CITY OF ALBUQUERQUE

PLANNING DEPARTMENT – Development Review Services

February 27, 2015

RE: Anasazi Ridge, Unit 3 (File: A10D002G)
Drainage Report, 1-12-15
Grading and Drainage Plan. 2-2-15
Supplemental Rundown Calculations, Engineer's Stamp Date 2-3-2015

SPILLWAY & CONCRETE CHANNEL DETAIL - TRACT A
SCALE: 1"=5'
(CHANNEL CONSTRUCTION AT DRC PER
C.O.A. STD. DWG #2260)

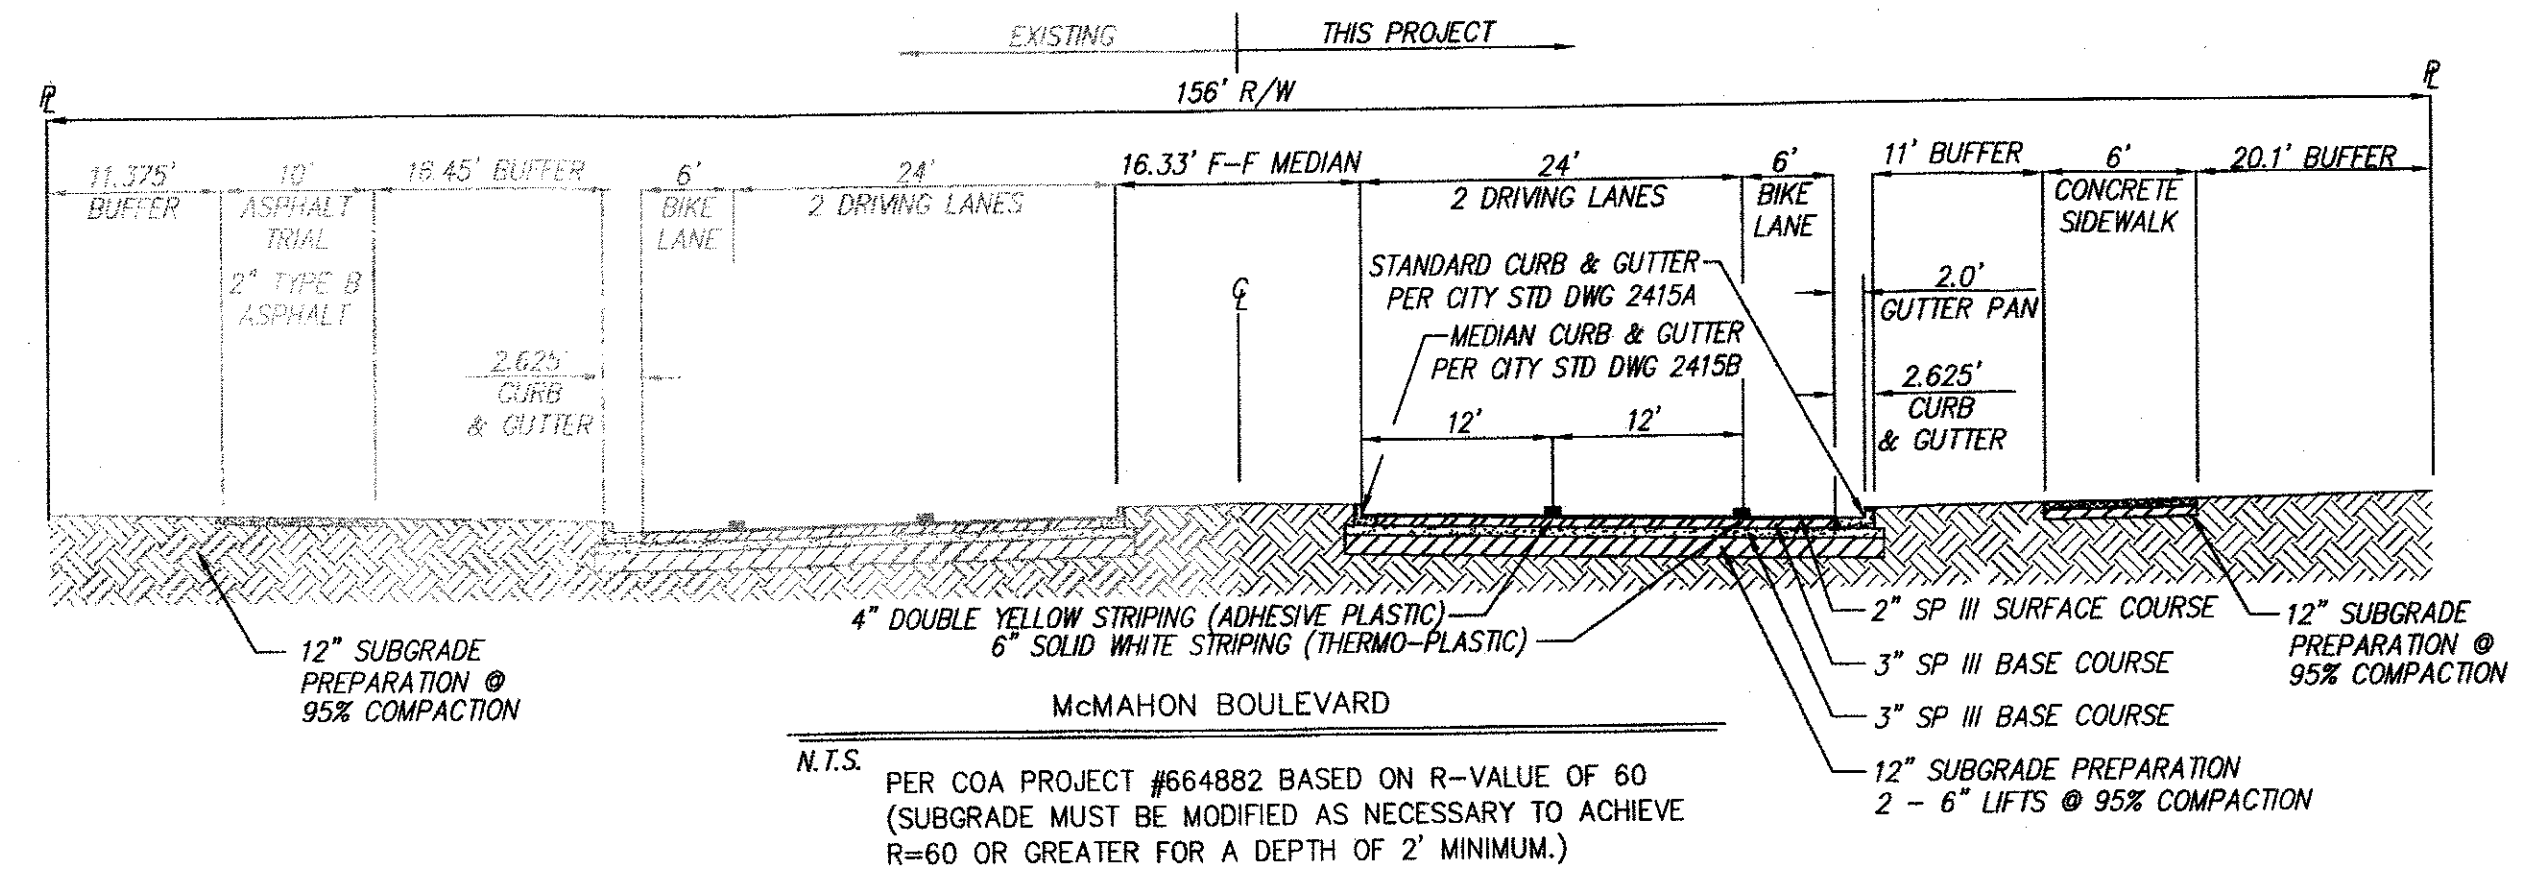
- PO Box 1293
Albuquerque
New Mexico 87103
1. Since the property drains to the Calabacillas Arroyo, AMAFCA approval is a prerequisite for approval.
 2. Add to the Infrastructure List the landscape strip to be replaced on Calle Vizcaya up to Calle Grandia Road
 3. Show the spillway cross-section on the Grading Plan.
 4. Indicate on the plan the landscape strip is to be replaced with concrete.
